Subject: Mitchell (SPF-18-00007) Final Short Plat – Staff Review and Request for Additional Information

MEMORANDUM

SUBJECT: Mitchell Short Plat SP-17-00007

NANEUM ROAD SHORT PLAT

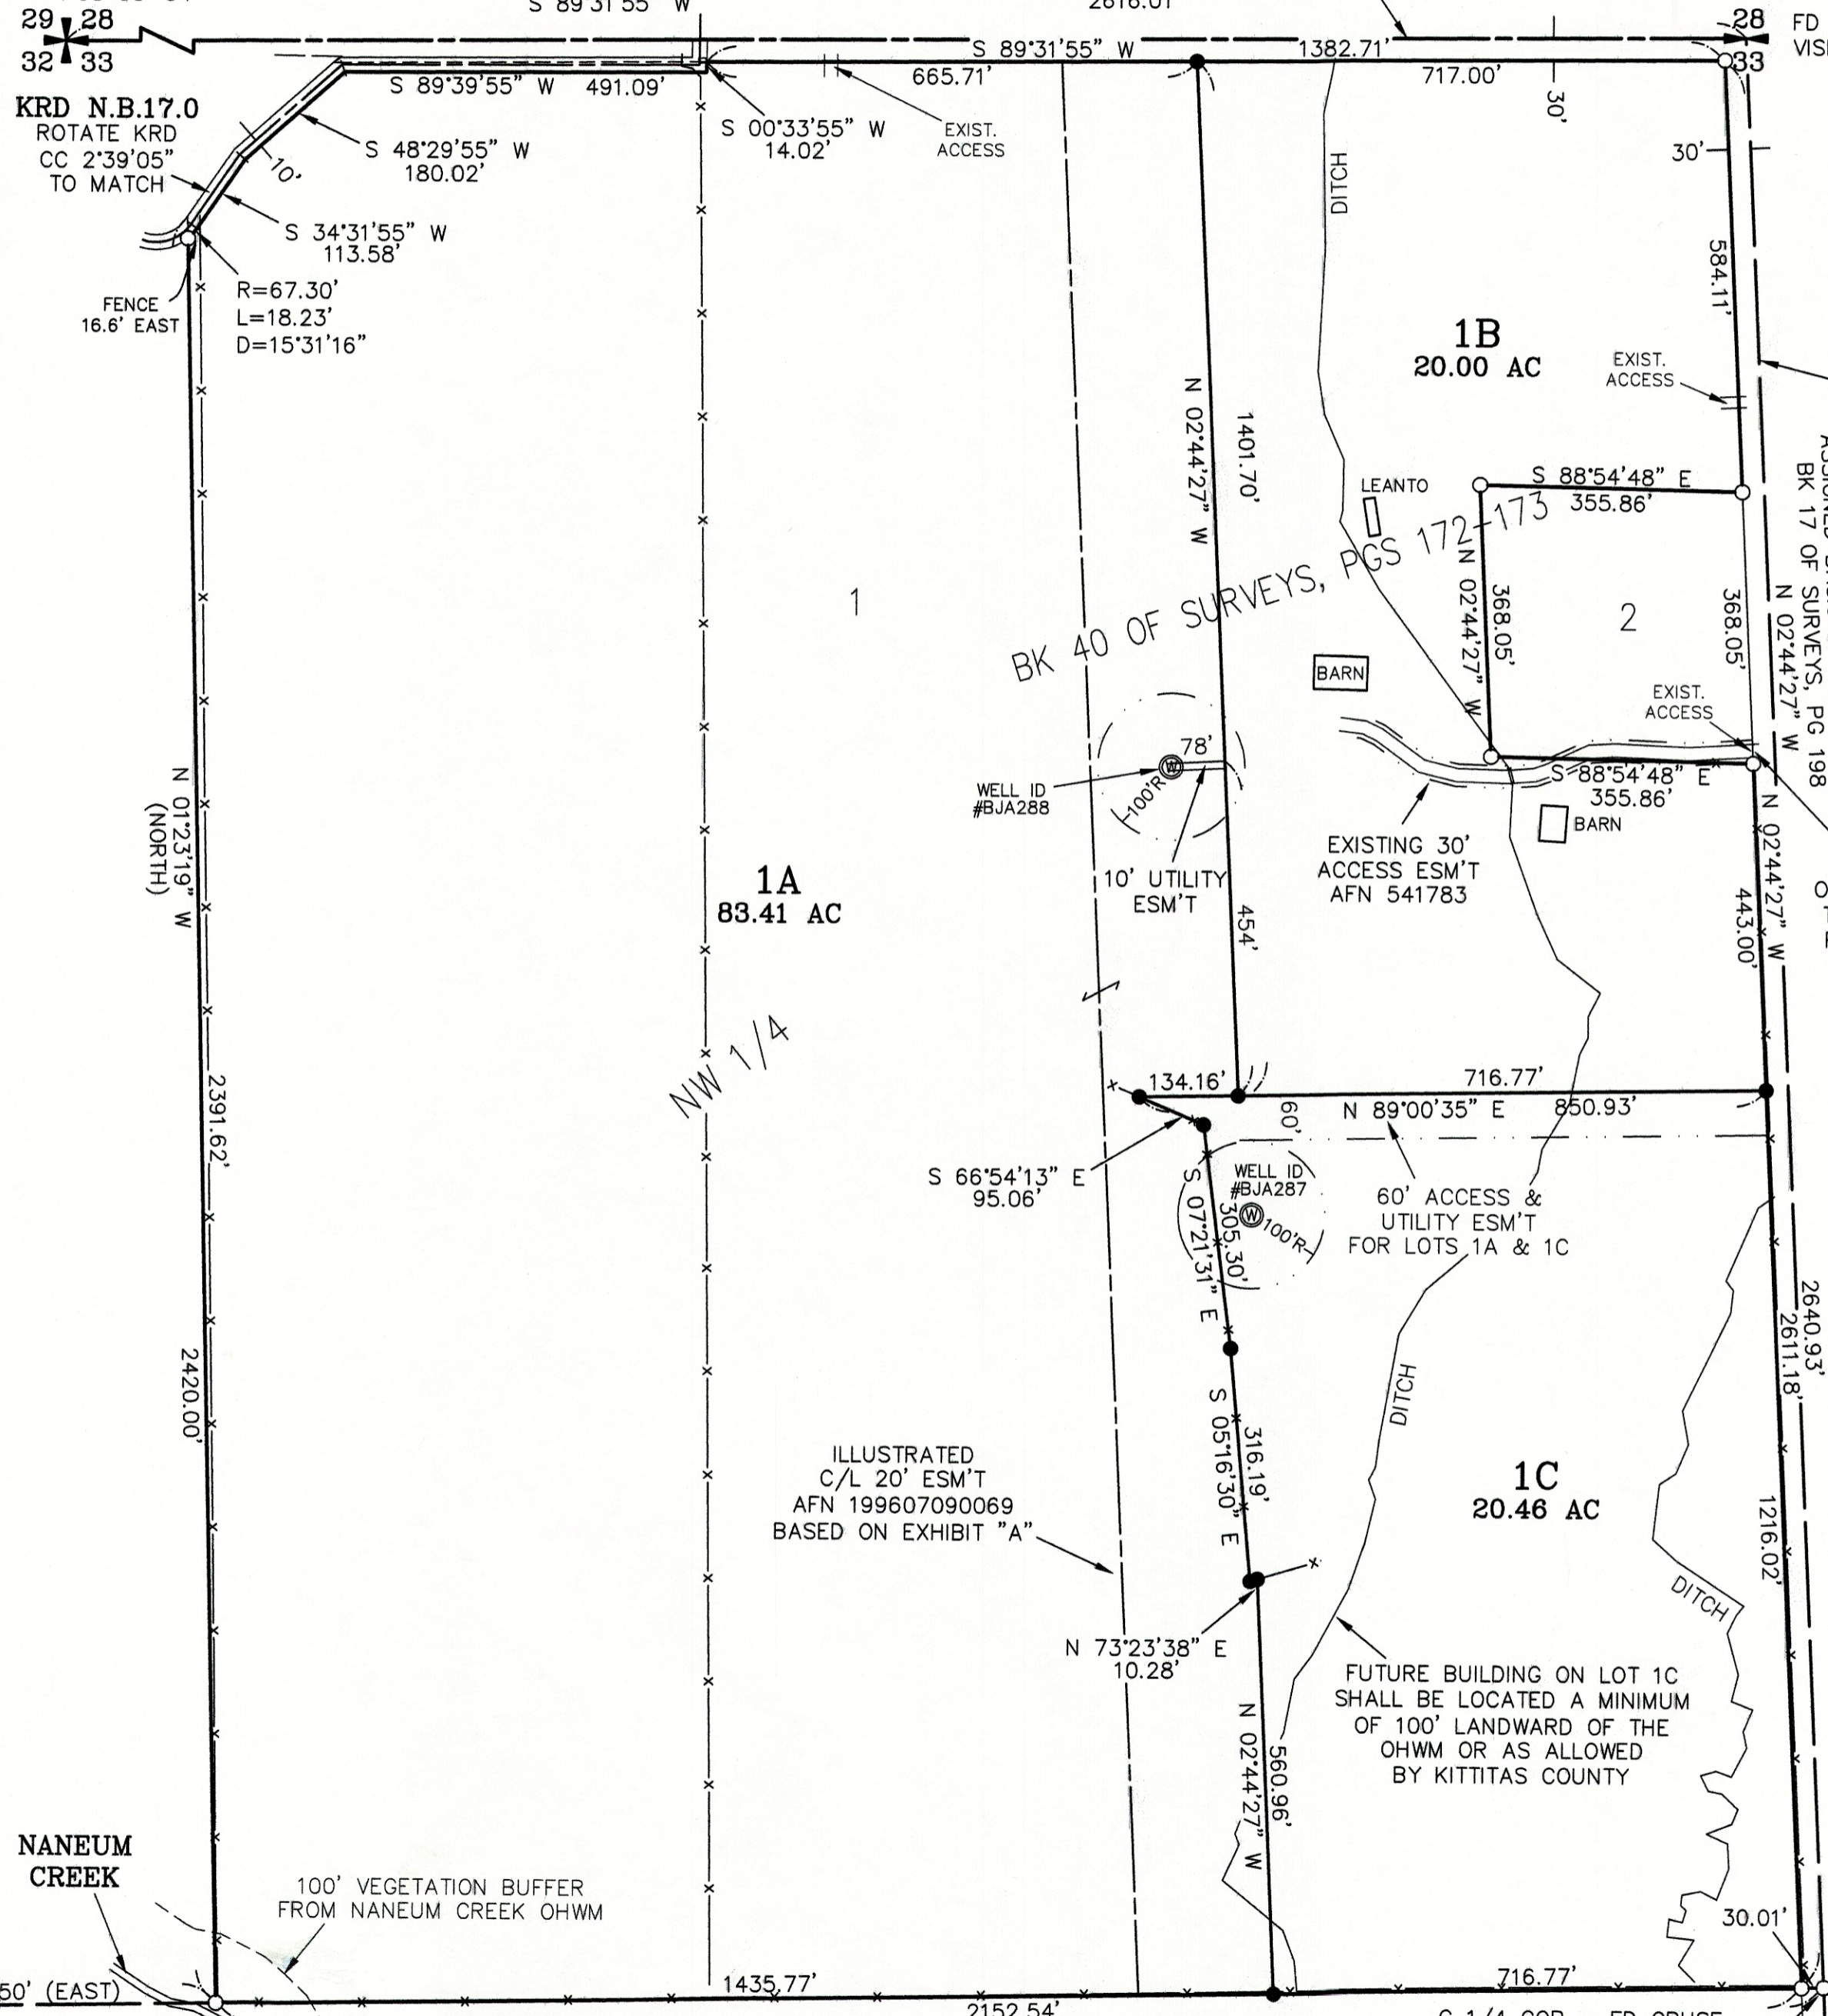
1. Please see attached memo dated December 12, 2018. The materials submitted do not address this requirement to the satisfaction of Public Works. The following items must be addressed:
 - a. The northerly existing access onto Game Farm Road to lot 1A needs to be labeled as an "Existing Agricultural Access."
 - b. The northerly existing access to lot 1B, north of lot 2, needs to be labeled as "Existing Agricultural Access".
 - c. The existing access at Lot 2 with a 30' existing access easement shall be brought to joint-use driveway standards.
 - d. The 60 foot access easement to lots 1C and 1A to be constructed to a joint- use driveway standard.
 - e. A driveway shall serve no more than two tax parcels. See Kittitas County Road Standards, 12/15/15 edition.

1. Lot 1A - Existing Access: The northerly existing access onto Game Farm Road to lot 1A needs to be labeled as "Existing Agricultural Access".
2. Lot 1B – Existing Access: The northerly existing access to lot 1B, north of lot 2, needs to be labeled as "Existing Agricultural Access".

3. Lot 2 and 1B: The existing access at Lot 2 with a 30' existing access easement shall be brought to joint-use driveway standards.
4. Lot 1C and 1A: The 60 foot access easement to lots 1C and 1A to be constructed to a joint-use driveway standard.

5. Driveways: A driveway shall serve no more than two tax parcels. See Kittitas County Road Standards, 12/15/15 edition.
 - a. New access easements shall be a minimum of 30' wide. The roadway width shall have a minimum width of 12' if the length of the driveway is less than 150', or 16' if the length of the driveway is more than 150'.

- b. Maximum grade shall be 15%.
 - c. Crushed surface depth per WSDOT standards.
 - d. Maintenance of driveway approaches shall be the responsibility of the owner whose property they serve. The County will not maintain accesses.

- e. Any further subdivision or lots to be served by proposed access may result in further access requirements.
6. An approved access permit will be required from the Department of Public Works prior to creating any new driveway access or performing work within the county road right-of-way (see Kittitas County Road Standards).
